Metrolink submission (Railway Order) 2022

Ref: ABP-314724-22 Railway (MetroLink - Estuary to Charlemont via Dublin Airport) Order [2022] — case number 314724

Briefing note on issues at Glasnevin Station
(Coke Oven Cottages, Shandon Mill, Royal Canal Cleanup Group & PVTT)

Summary of issues and questions/requests for clarification from TII following meeting with residents and site walk on Saturday 3rd February 2024

Figure 1 Metrolink Scheme and Irish Rail Line Interchange

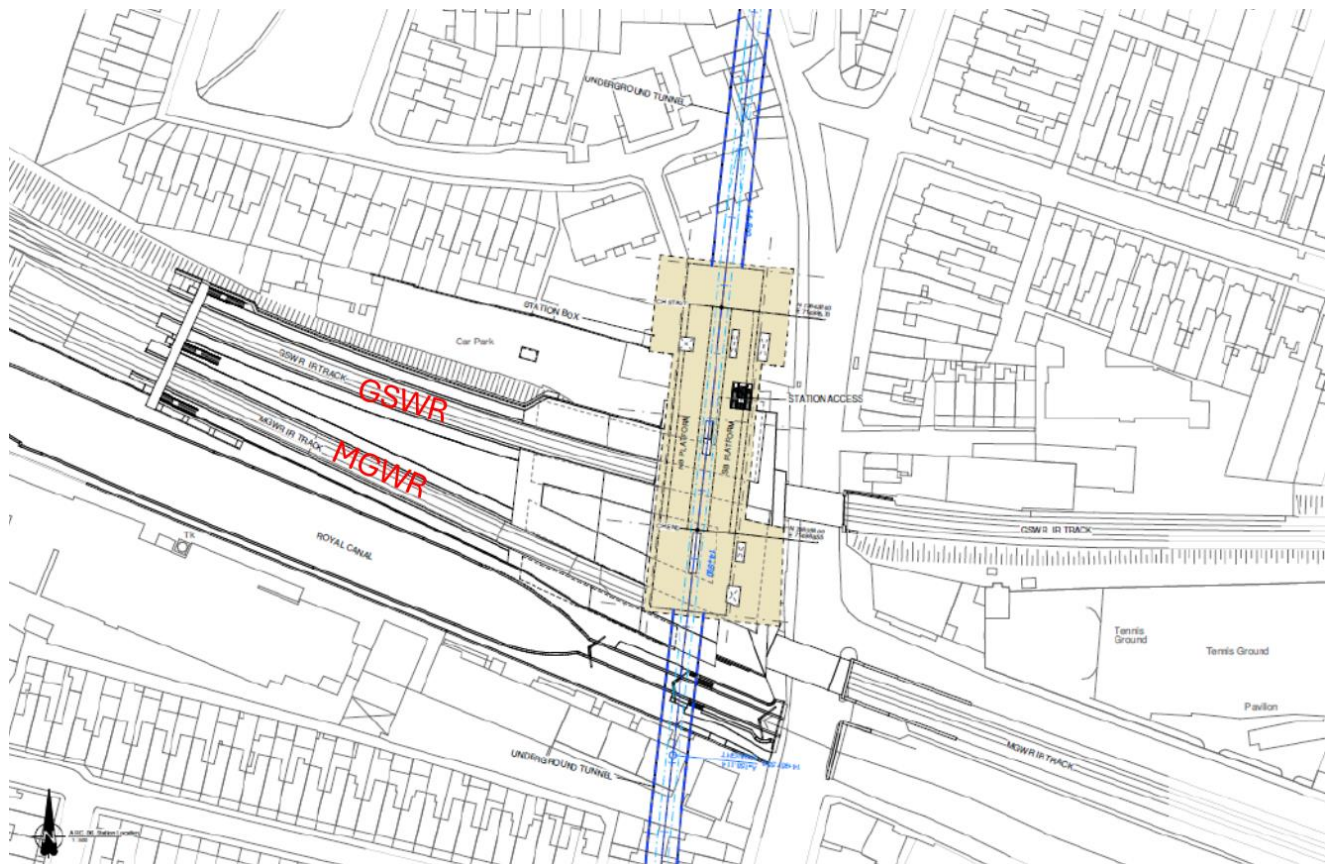
Residents of COC have asked for clarification of the duration of proposed MGWR track lowering activity N of COC and arrangements that will be available to them for relocation given the expectation of high noise levels (even with mitigation).

- Reference to pages 84 (plan drawing of MGWR track lowering activity N of COC) and 86 (longitudinal section for the same stretch) show that this activity will be west of chainage 850, and therefore RA infers that the duration of the track lowering N of COC will be 2 weeks.

Please could TII confirm that RA's interpretation of the information is correct as well as providing COC residents with information on temporary relocation options for this period?
